Mallard Pass_ISH2_12 July_PT2

Okay. Thank you. We're on to item. Uh, f no, sorry. E of for which is the representative and representative and illustrative viewpoints and photo montages. Uh.

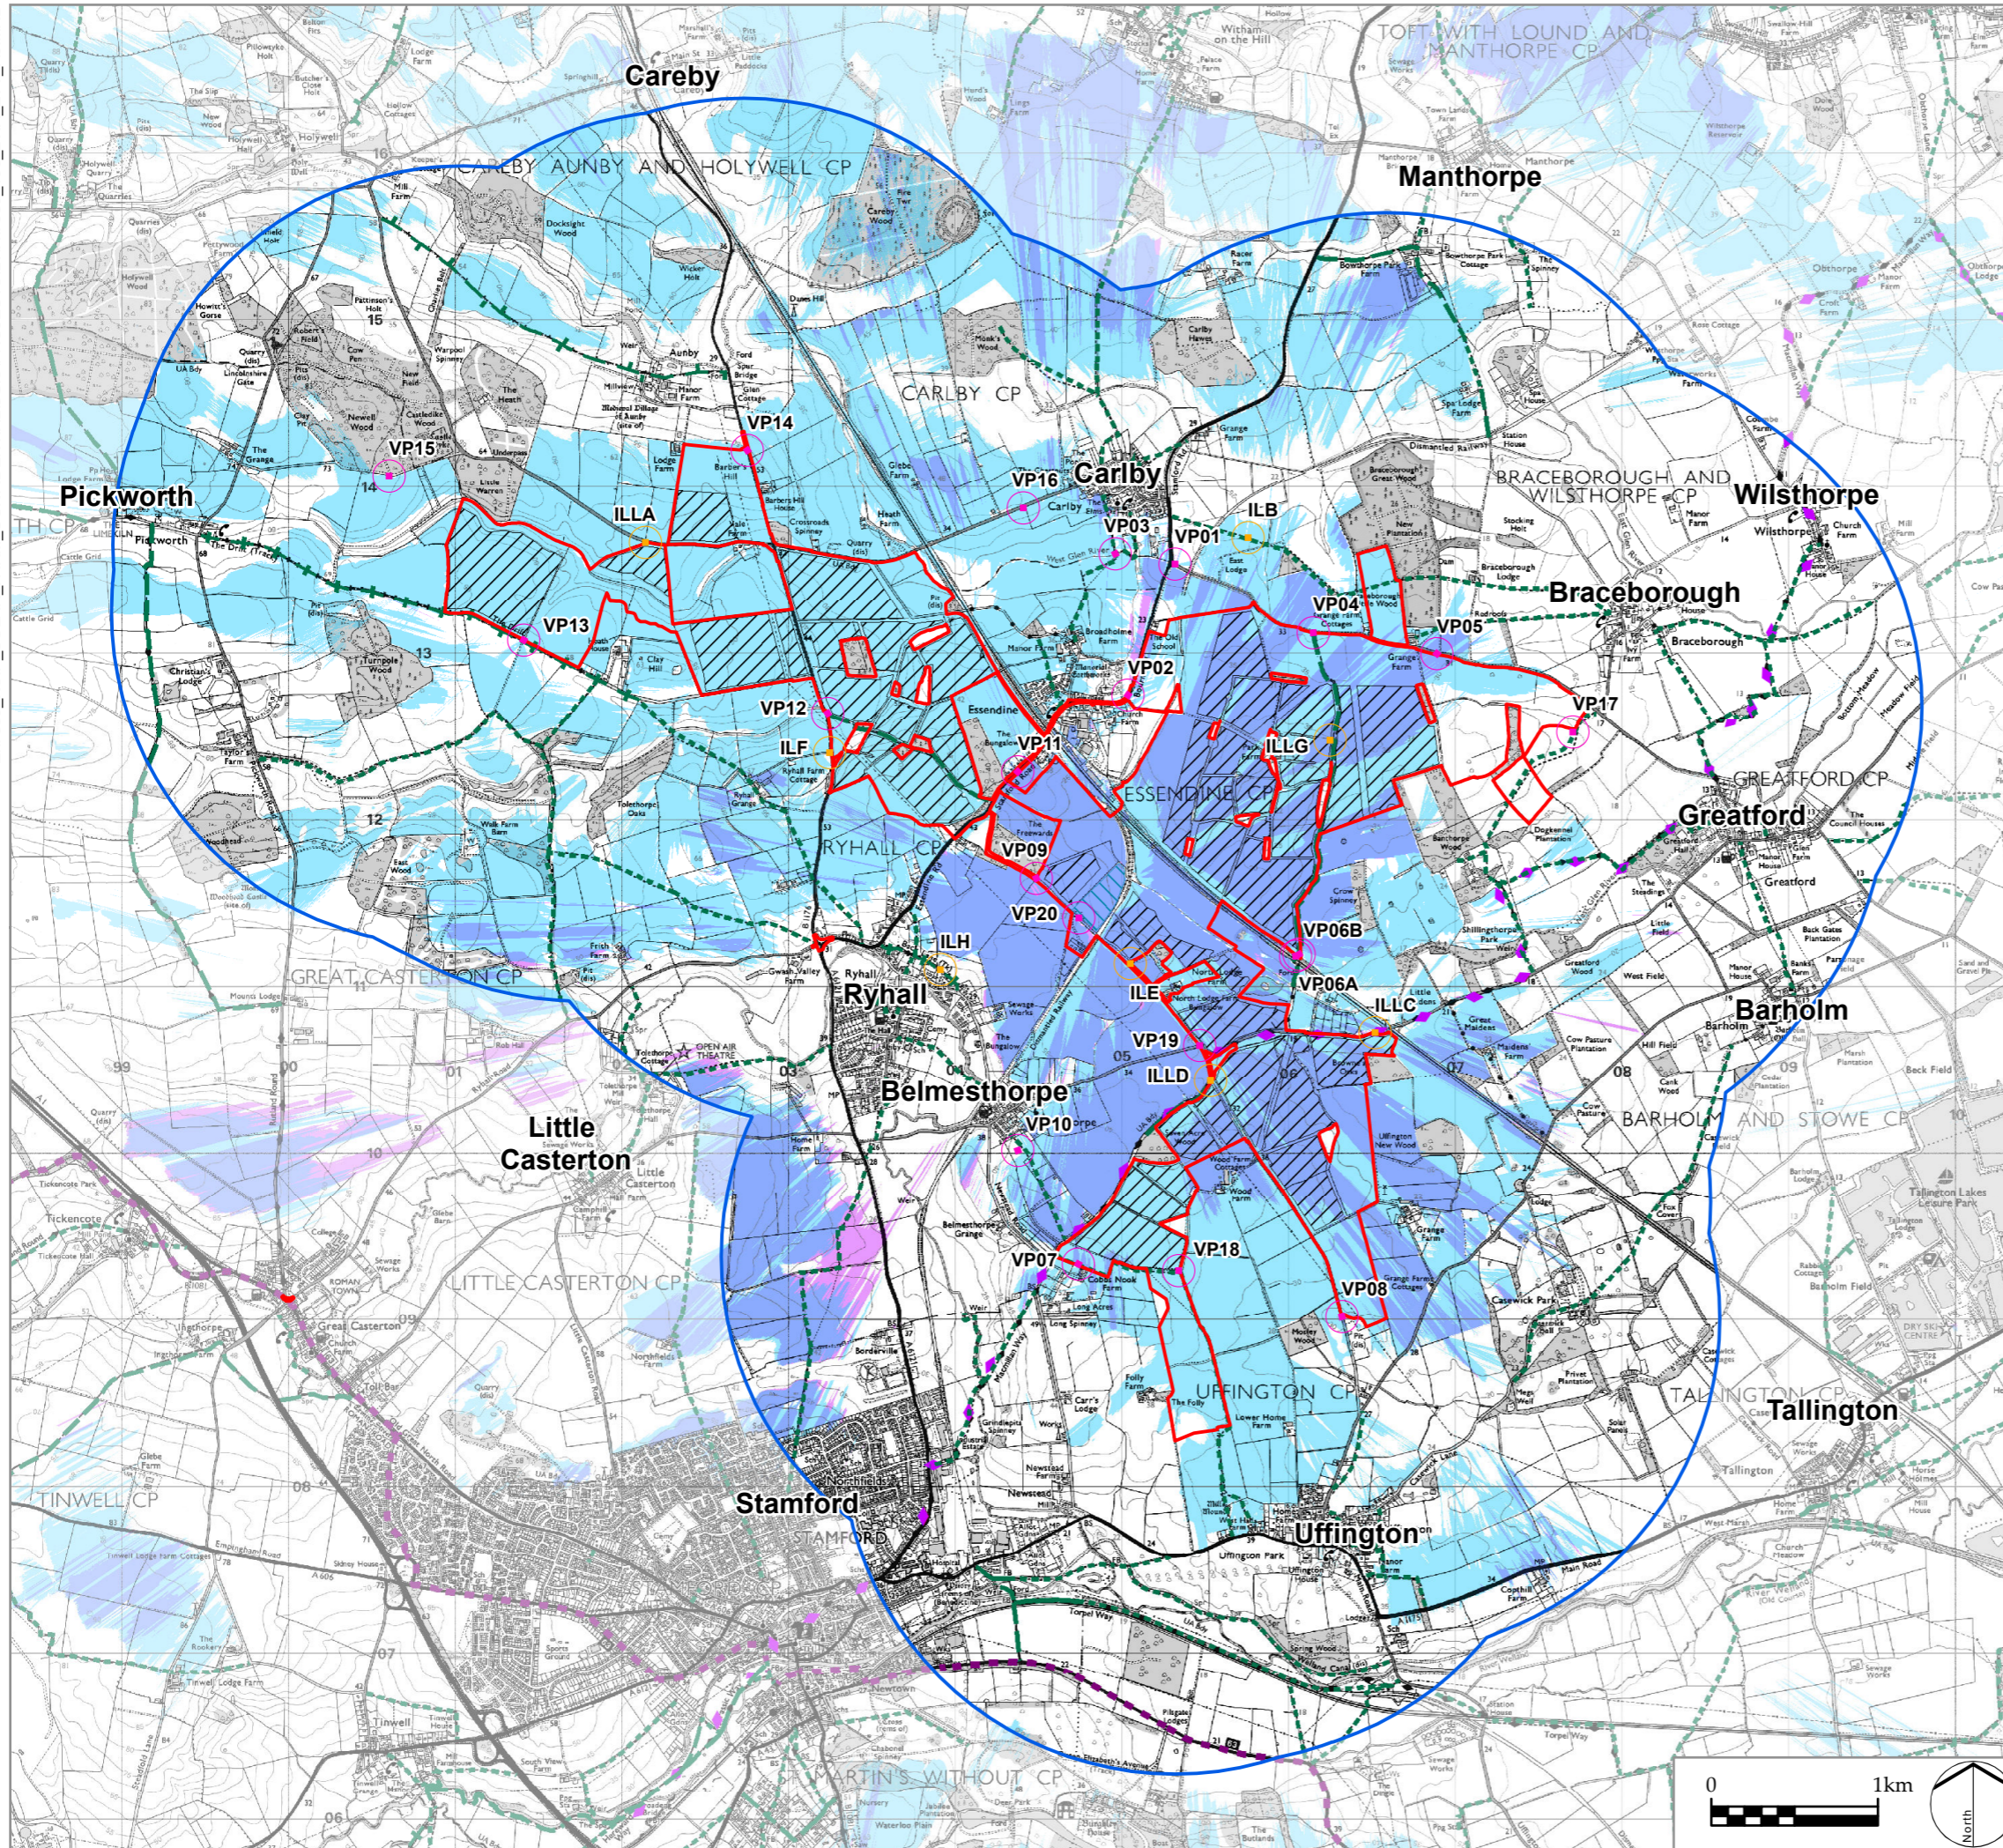
Um, yeah, Um, we have, we have provided comments on the viewpoint locations and our major concern was that the fine grained location hadn't been sent through. So we hadn't seen, um, evidence of where the exact location that had been chosen. We'd sort of commented on a generalized location. Um, in some instances we, we do think this does have an impact, um, because there's, there's viewpoints where if you, if you'd gone a few meters down, down the footpath, you would have had a more representative view than what was actually chosen.

And there's some instances where they're heavily dominated by a hedgerow, whereas just the a little bit more finer selection you could have had, you would have still seen the hedgerow, but you, you would have had a much more wider significant view. So it's more it's more the fine grained location.

chosen and you go five, ten, 20, 20 yards down. And that's even to the extent of a recent photo montage that was taken and added has been put in a place, again, exactly the same principle. You move you move up to the top point of the hill, you can see. Seven seven fields across to the north of the site, but where it was taken.

Thank you, sir. Thank you. On behalf of the applicant. So in terms of the process of assigning the dew points, we we've, as I say, cover that previously, but based on fieldwork, desktop study, consultation with with the local bodies. And I would in just direct response to Mr. Gillespie, there was a technical note produced by those. I'm not sure if that's in by by his company he hates. I'm not sure if that's in front of you, but that was a technical memorandum based on discussions and the site visit identifying a number of dew points to be added all within one kilometer that we did incorporate within the hour.

So there was opportunity, ample opportunity, in my view, for for those additional viewpoints to be incorporated. And they have been done. So if if you haven't seen that note. So I'm sure that's something we could we could supply.
